Outline application with some matters reserved for demolition of existing detached dwelling & erection of 2 no. 5 bed dwellings, double garage & alterations to existing access

69 Coastal Road Kingston

Objection: Council has no objection to the principle of there being two separate dwellings on this plot, but objects to the following as shown on the outline plans:

PROJECT			Proposed development at 'Simcar' Coastal Road, East Preston
SUBJECT			Plot 1 -Indicative Plans and Elevation
SCALE	DATE	DRAWING No	
1: 100	Nov 2011	11 / 46 / 02	
DRAWN	CHECKED

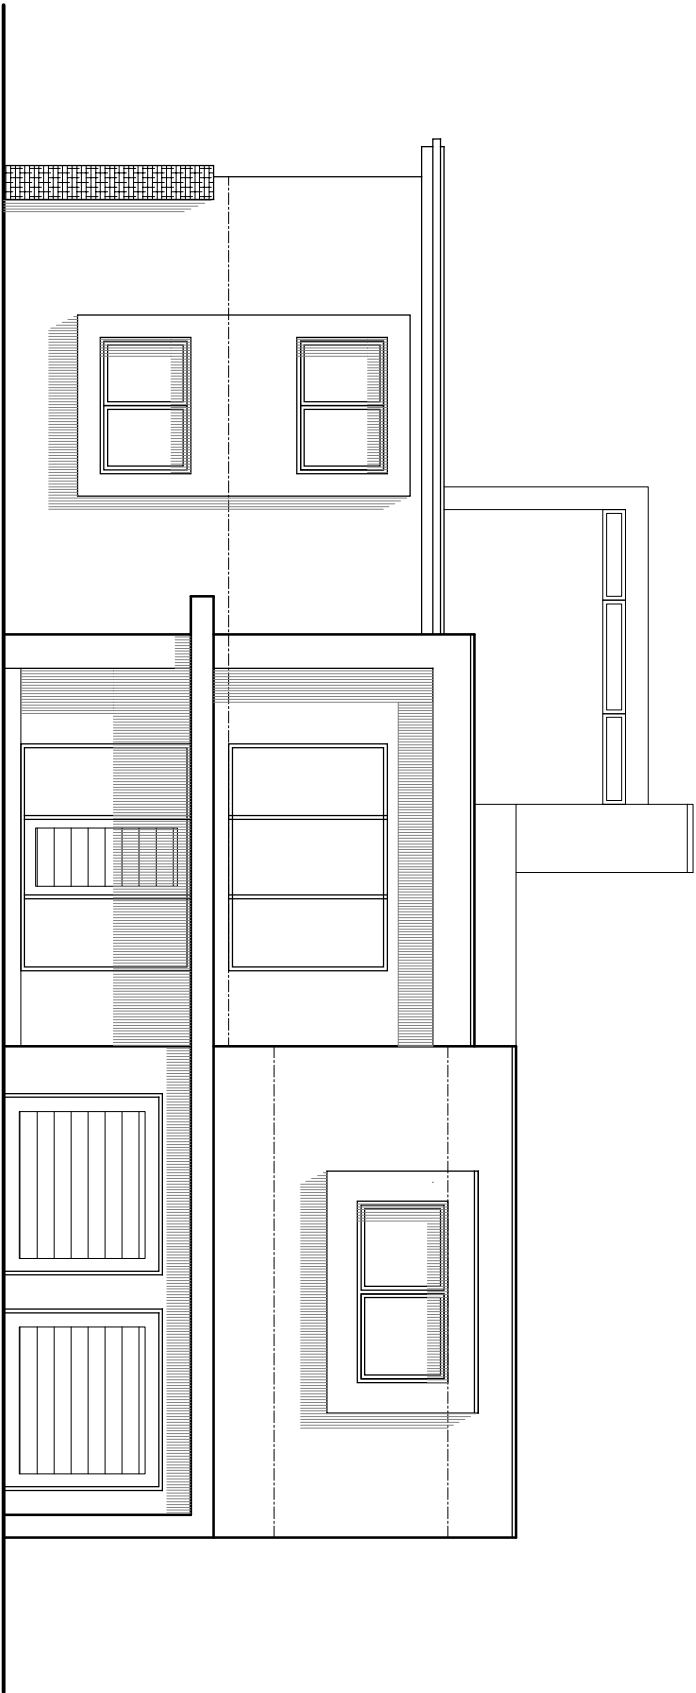
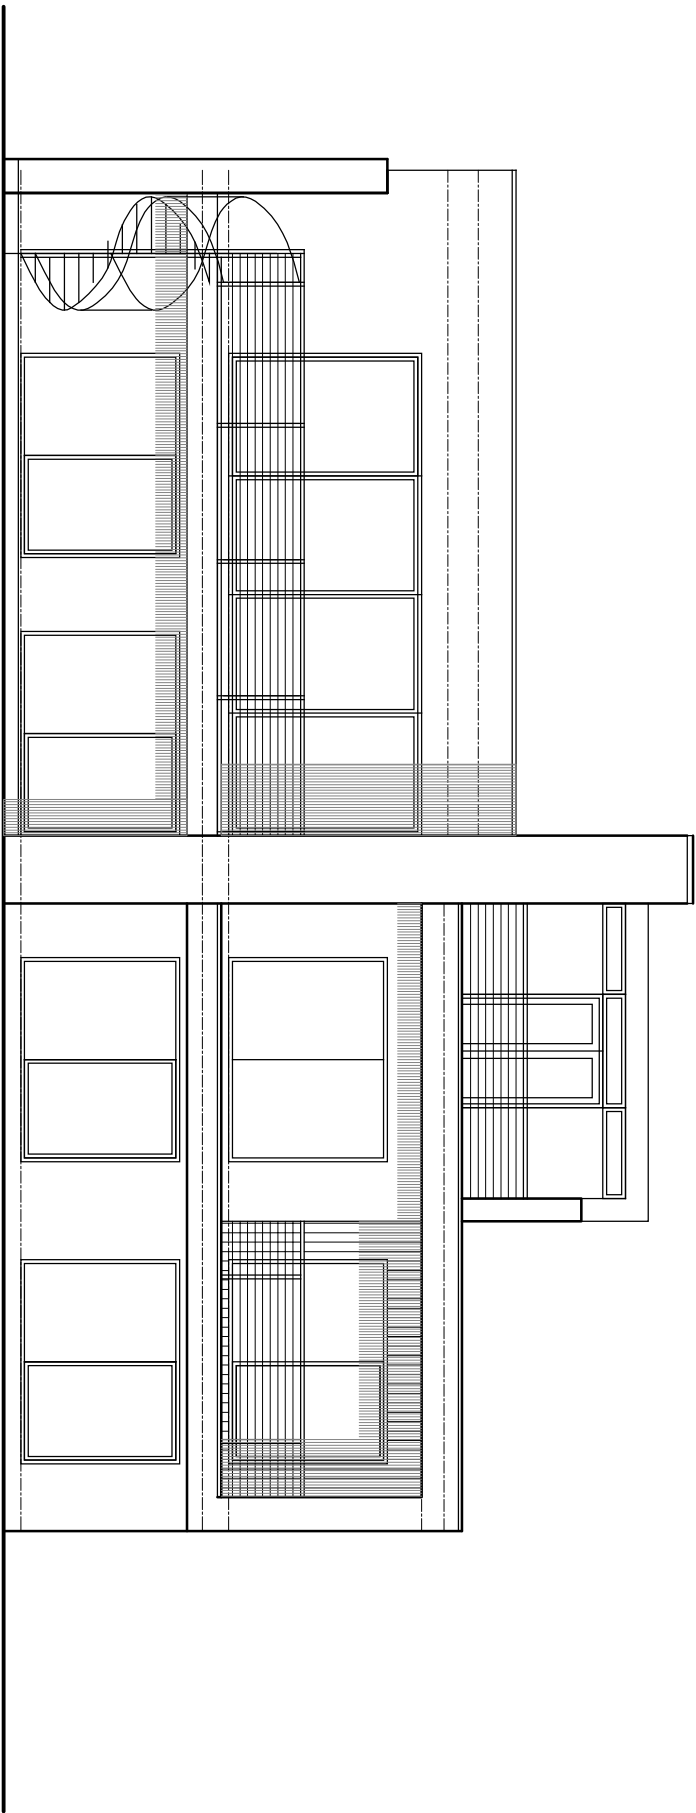
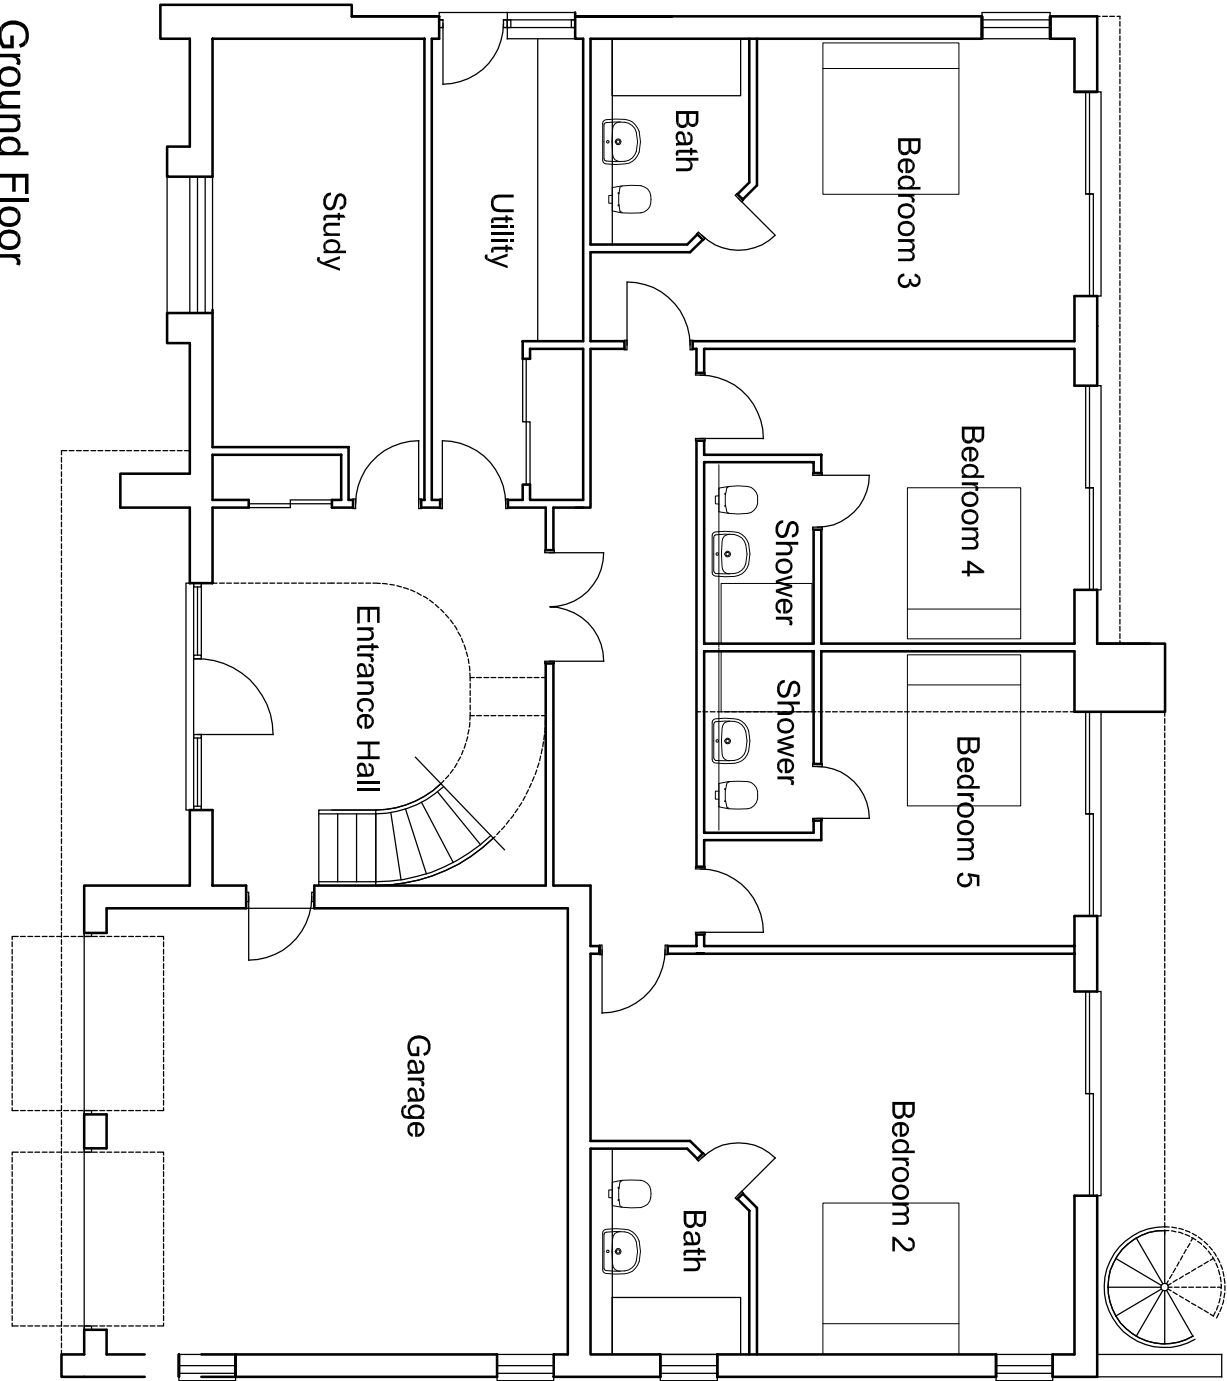
- 1. To maintain the character of the street scene and not adversely affect the amenity of the area the houses should not exceed two storeys.*
- 2. The garage shown on plot 2 is effectively in the front garden: this is detrimental to the street scene. The garage should be in line with or integrated into the house.*
- 3. The existing turning circle for all vehicles using Coastal Road should be retained.*
- 4. Council is concerned that first floor balconies are intrusive to the privacy of neighbouring properties and should be fitted with side privacy screens to preventing overlooking (Council accepts that this may form part of any detailed application rather than this outline application)*
